Ref: DA: 609/2010
Date: 24 January 2011

Subject: Request for Further Information – Development Application
Ref: MP10_0105 / DA 609/2010
Property: 40 Walker Street RHODES 2138 (Sites 2A & 3A)

HYDRAULIC SERVICES
COVERSHEET
STORMWATER
CONCEPT PLAN

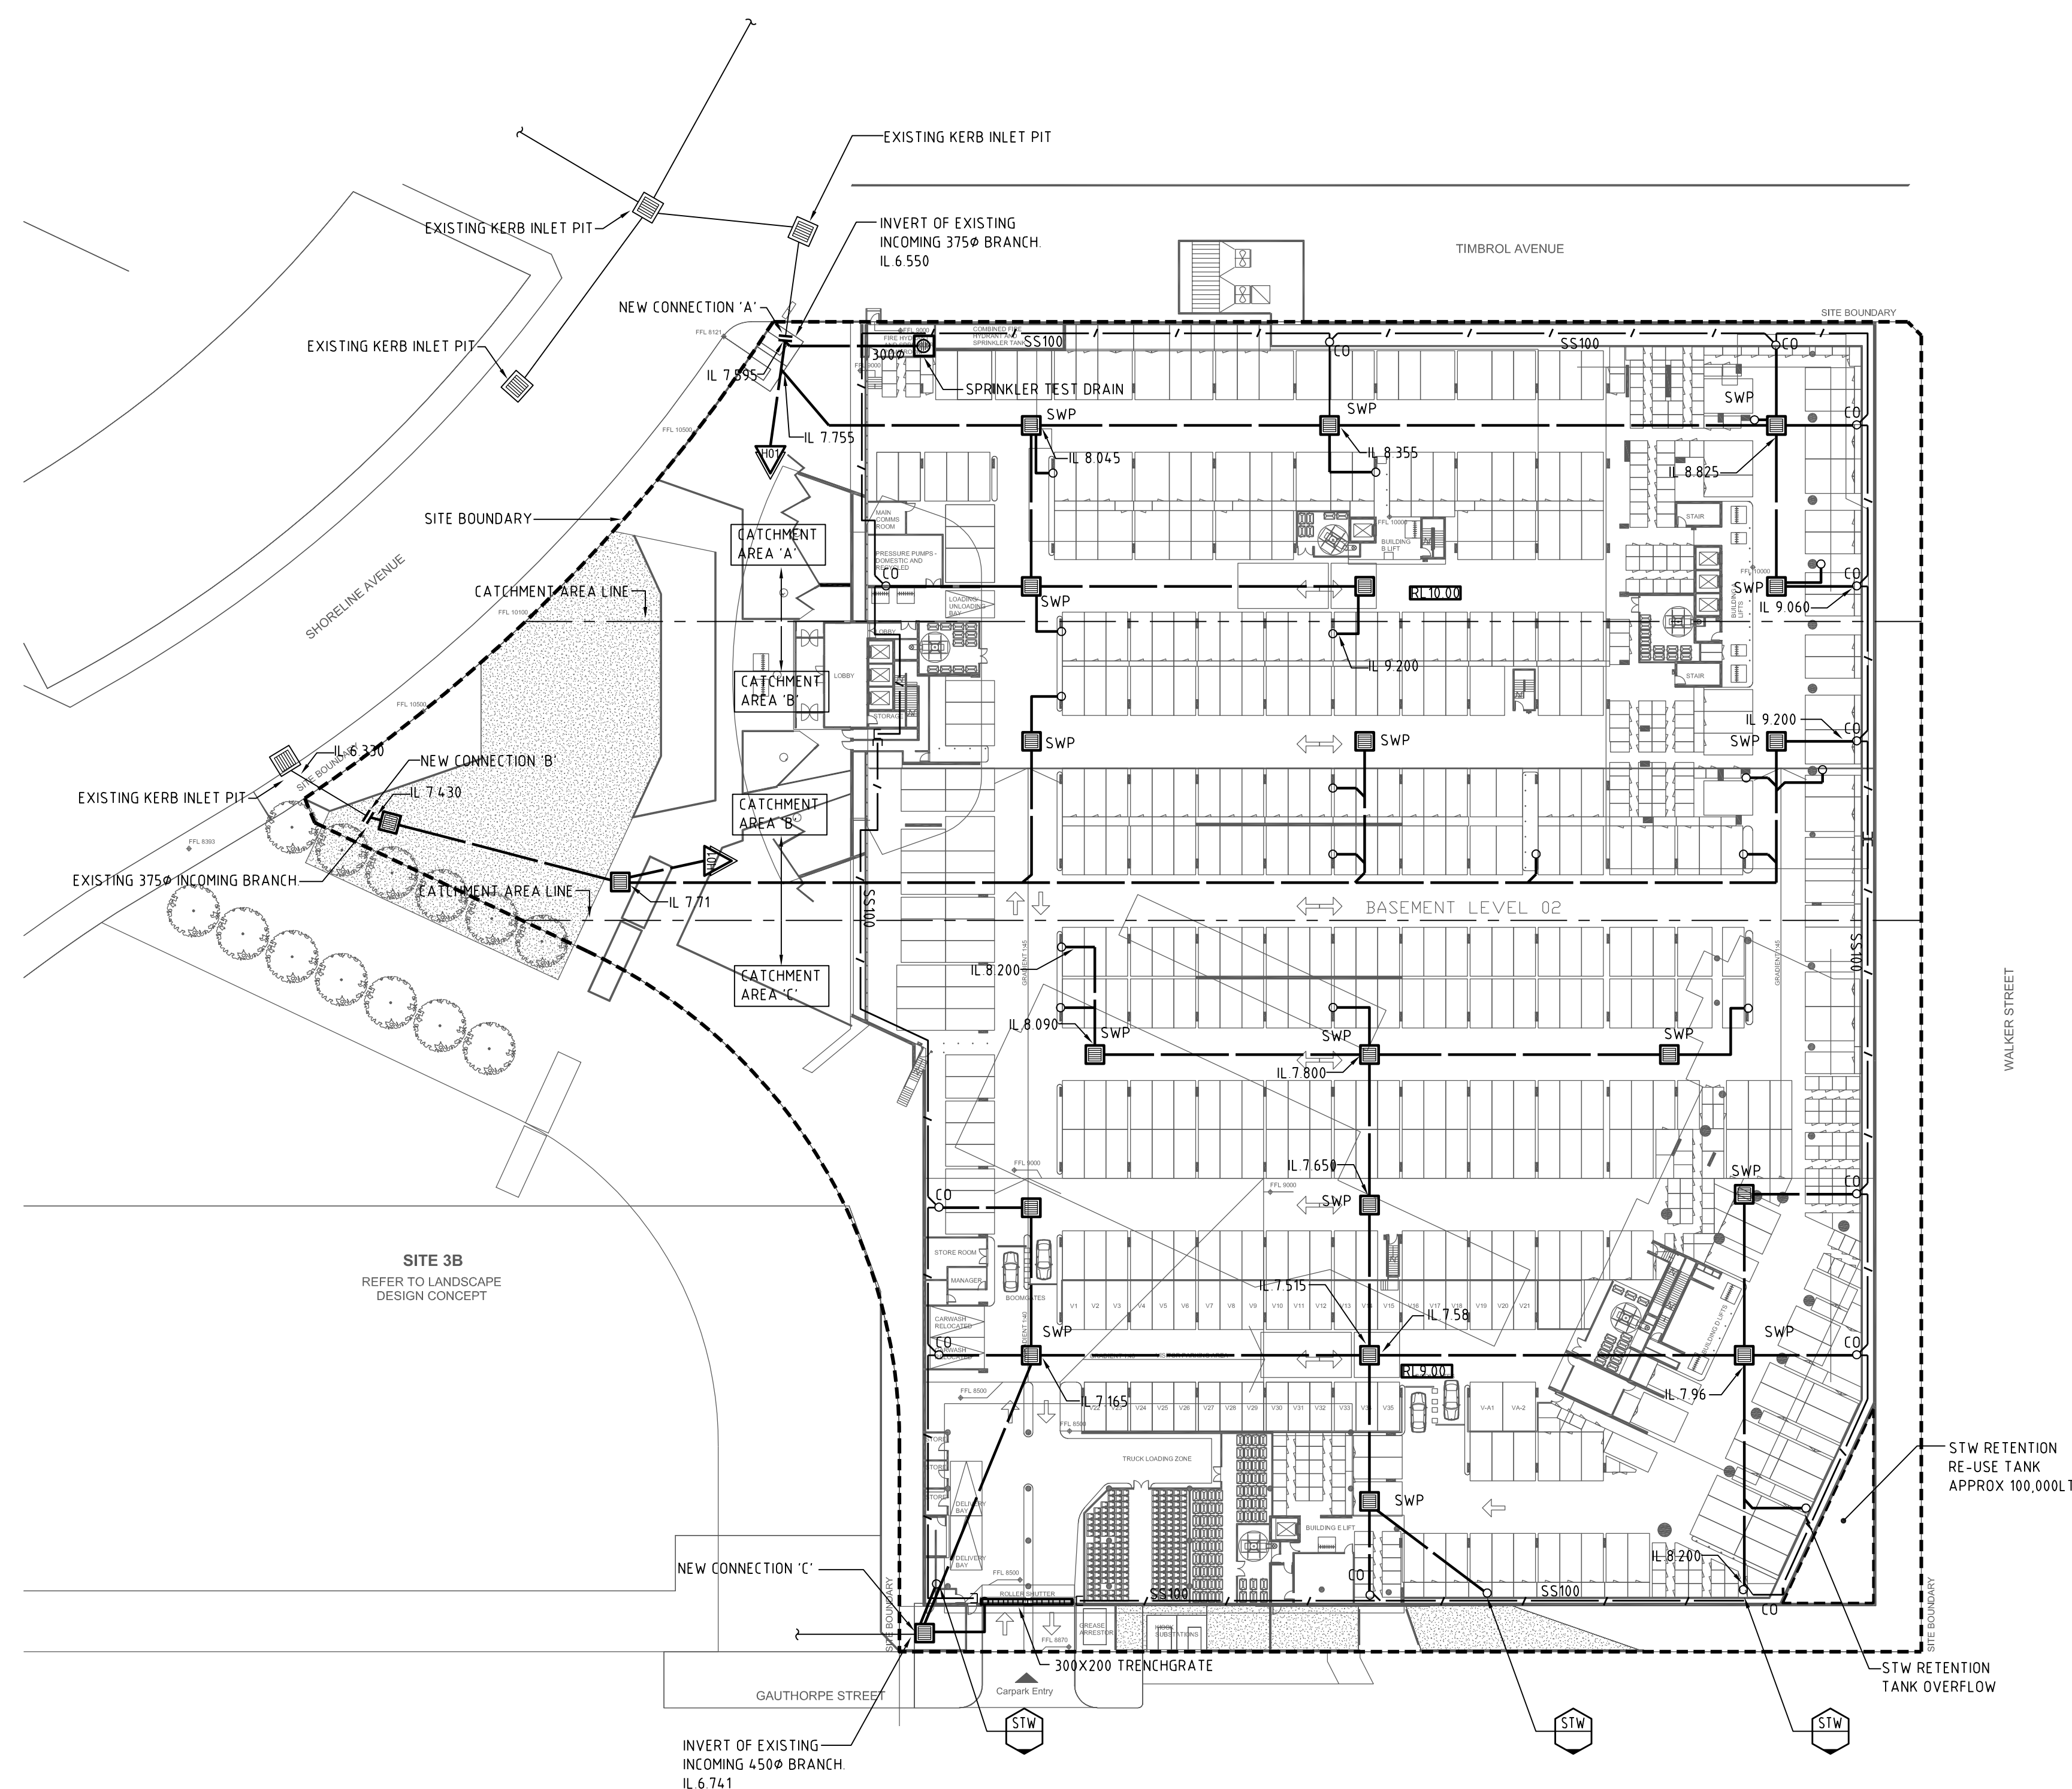
- The stormwater drawings issued by Cardno ITC shows the location of downpipes but the sizes of these downpipes have not been identified. Please note that the minimum pipe size for charged lines (as where directed to the rainwater re-use system) is 150mm-dia, solvent welded uPVC pipes suitable for pressure applications will be required. Construction specifications must refer to this.
- The shape of the rainwater re-use tank is inconsistently detailed on the drawings. Note reference drawing no. N10957-H01 indicates a rectangular shape but drawing no. N10957-STW-H01 indicates a triangular shape. Therefore the correct dimensions and shape of the tank must be confirmed or amended.

- A typical cross section through the re-use tank is required. Such detail is to include but not limited to:
 - the tank dimensions
 - overflow configurations and invert level of out-flowing pipes

- invert and finished levels
 - all connecting first flush devices
 - location of all access points
- The rainwater tank appears to be located in a landscaped area. Therefore the proposed depth of cover over the tank is required. Please note that a minimum of 1m cover over tank is required for deep soil planting. If this cover is less then it would be considered as impervious area.

- Supporting calculations are required to show how much site area is to be collected by the rainwater tank and what areas will bypass and be directly discharged to street drainage system. Please note that all stormwater from roof areas are to be drained to the rainwater re-use tank. Sub-surface water, water collected from balconies and on-ground areas not to be discharged into the rainwater re-use tank.

GRATED TRENCH DRAIN  
SCALE: 1:20

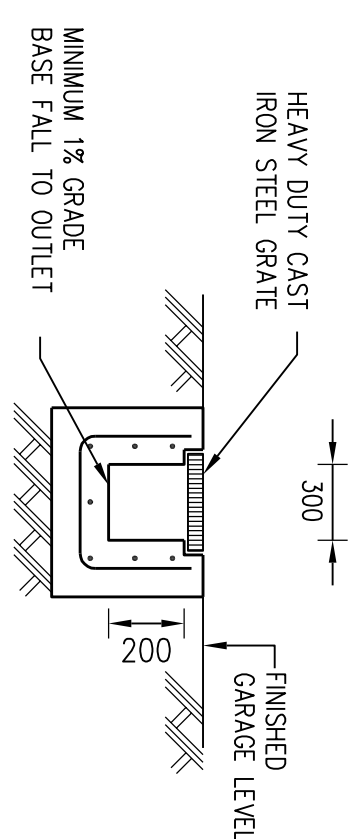
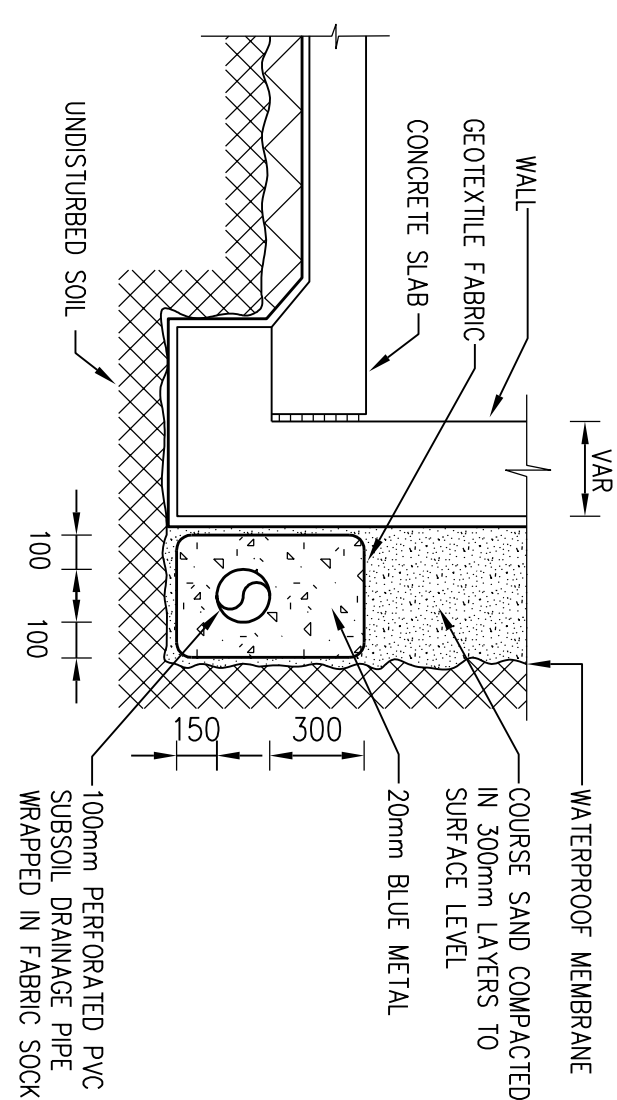
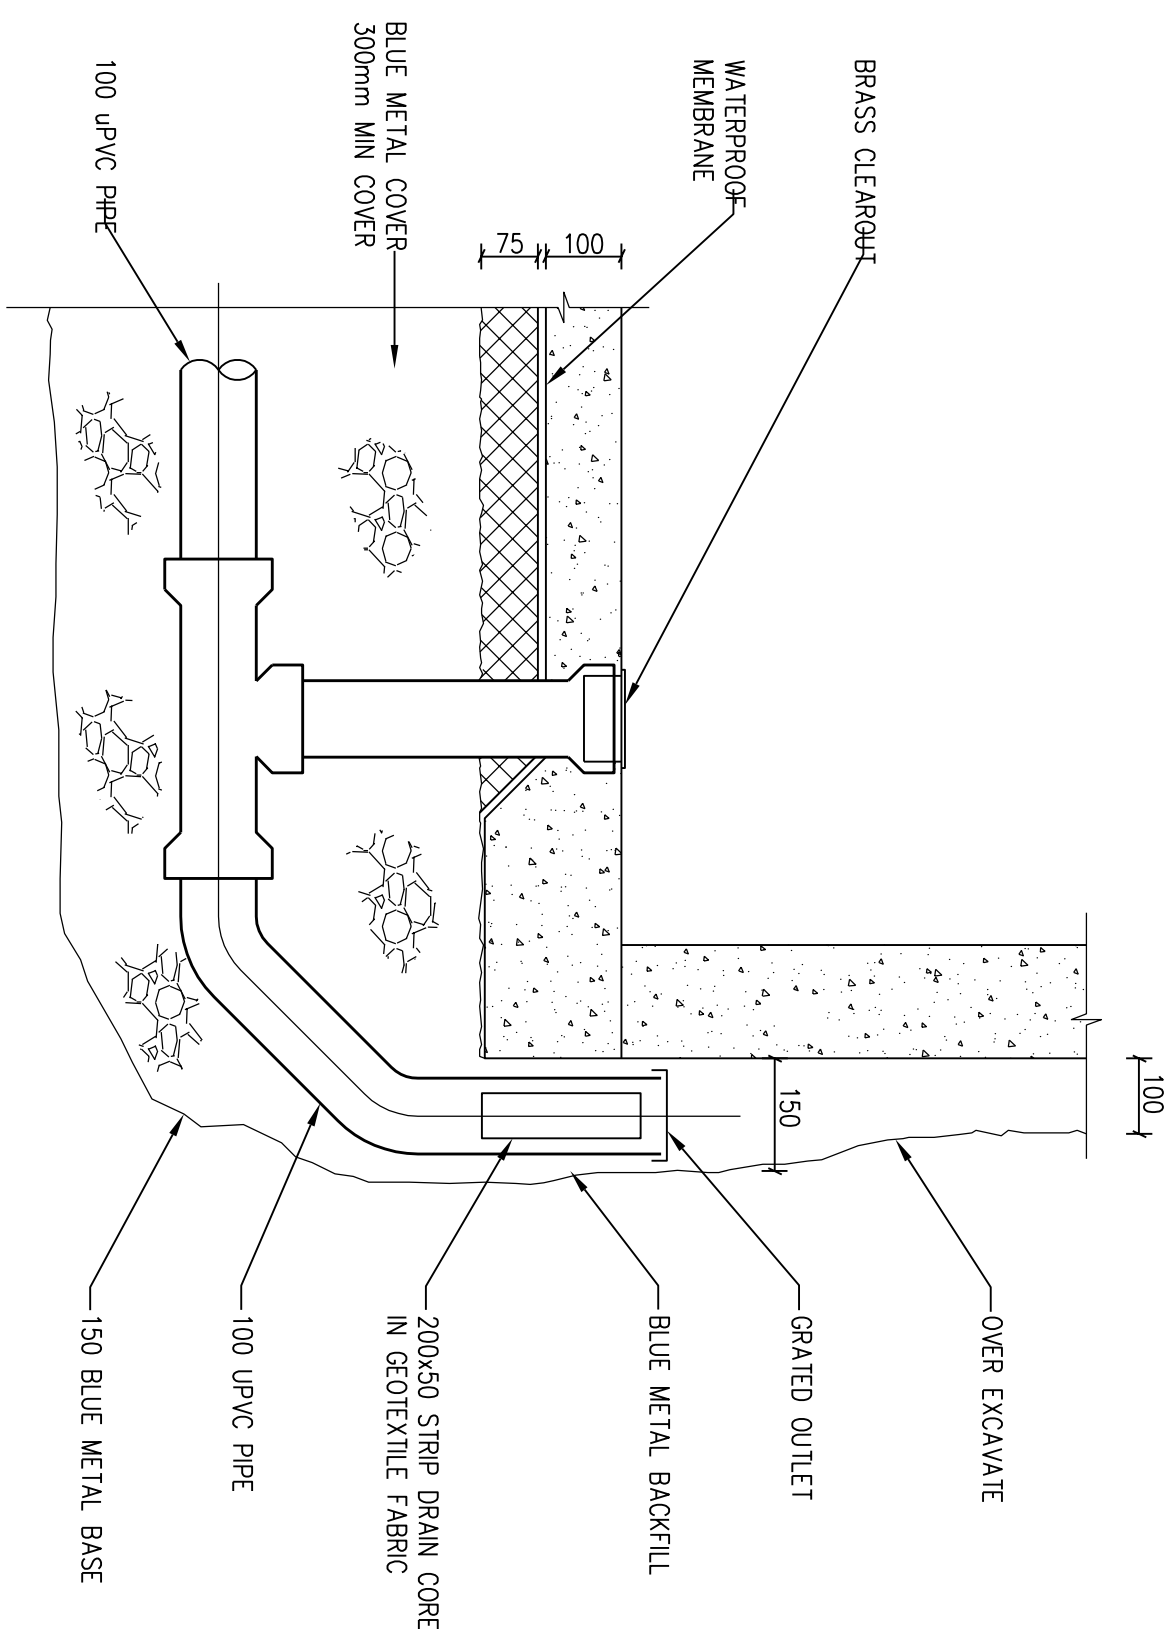
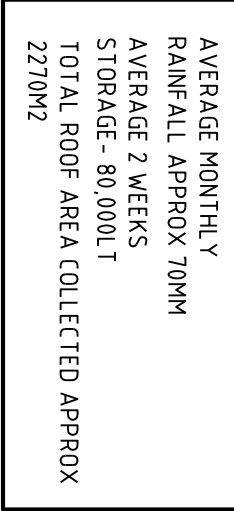
- A cross sectional detail showing the sub-soil drainage around perimeter of building must be provided. Where discharge is not by gravity, the mechanical pump-out system (where required) is also to be provided and detailed.

- Surface water collected from weather exposed areas from all driveway ramps draining into the basement must be collected by trench drains. In this regard, details of trench drains if required are to be provided / shown.

- All internal stormwater drainage pits are to have silt / sediment traps installed. Details are to be provided.
- A Soil and Water Management Plan is to be provided.
